# Rezoning Transportation Analysis

Petition Number: 2023-036

Date	Description
7-26-23	First Review (TM)

REZONING
SITE
PLAN

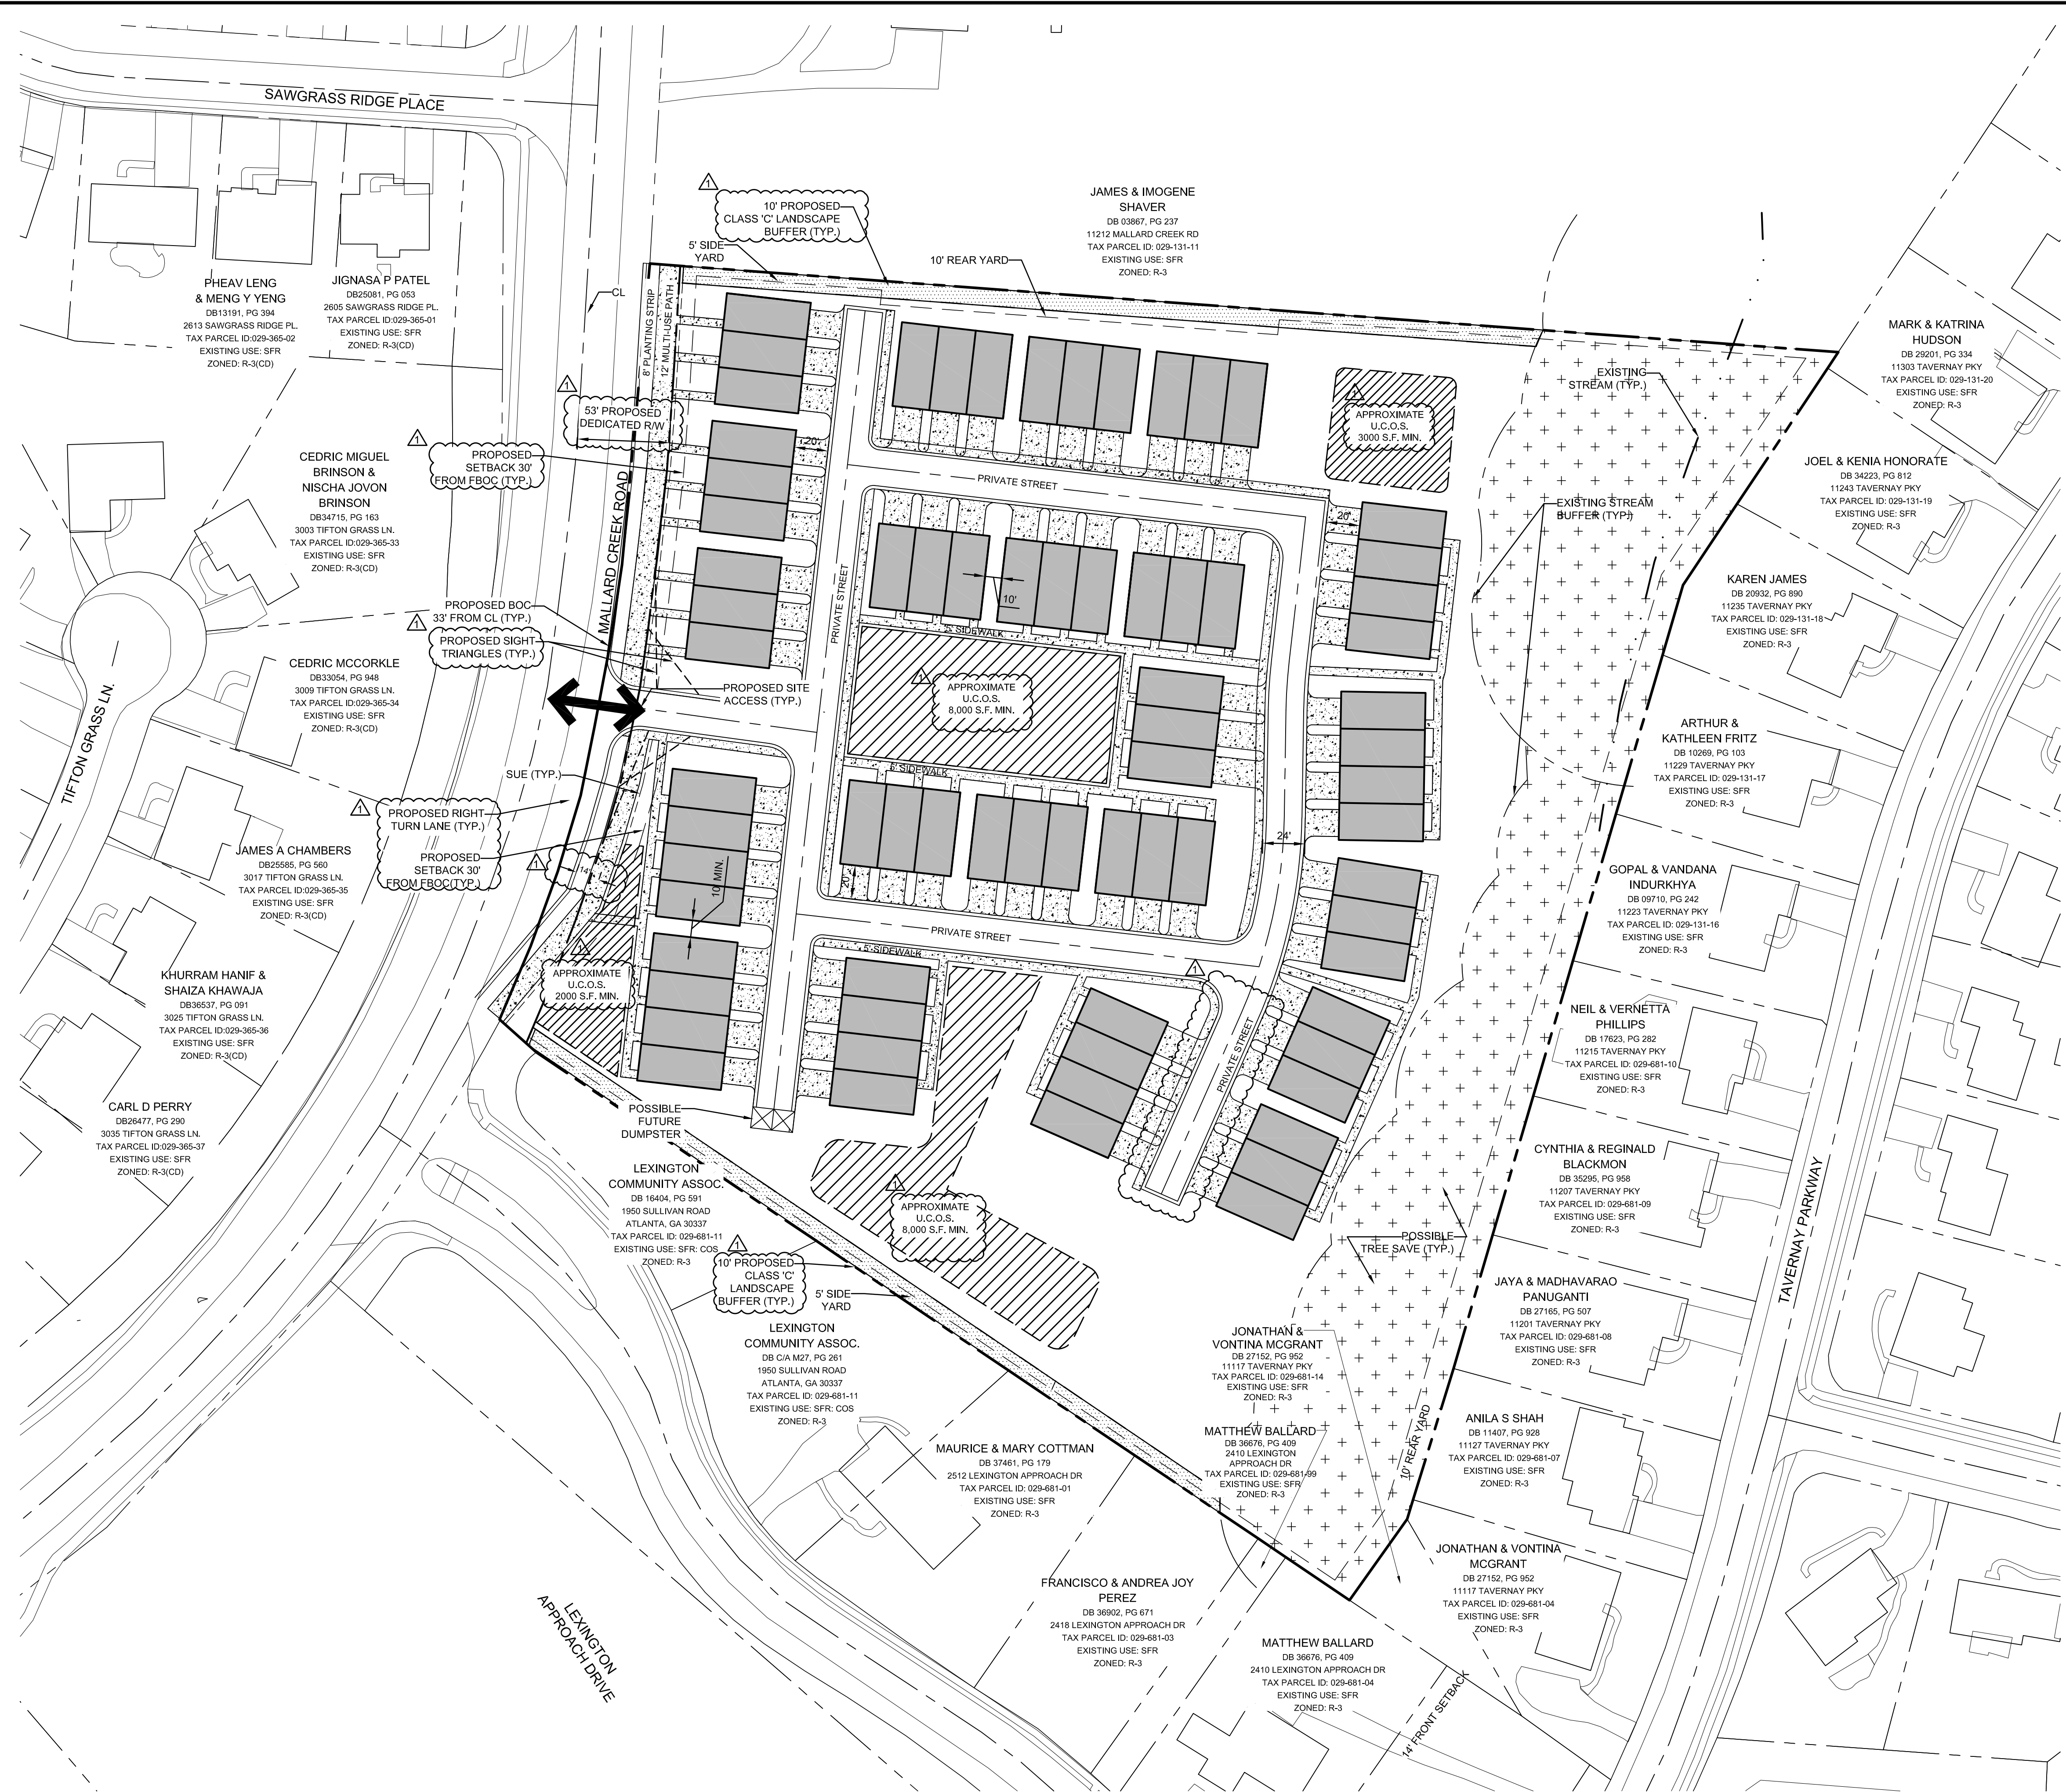
- a. **Mallard Creek Road:** Location of curb and gutter to be coordinated with NCDOT STIP U-6028. to accommodate the STIP project along with Charlotte Streets Map with a roadway typical section of 4+ Boulevard with a Shared Use Path.

Label and dimension the curb and gutter from the centerline for each road on the site plan.

4. Revise site plan and conditional note(s) to commit to coordinating with NCDOT regarding STIP U-6028. Site plan shall show U-6028 on the rezoning plan.

5. Revise site plan and conditional note(s) to commit to constructing a dedicated right-turn lane into the site with 100-feet of storage in coordination with NCDOT.
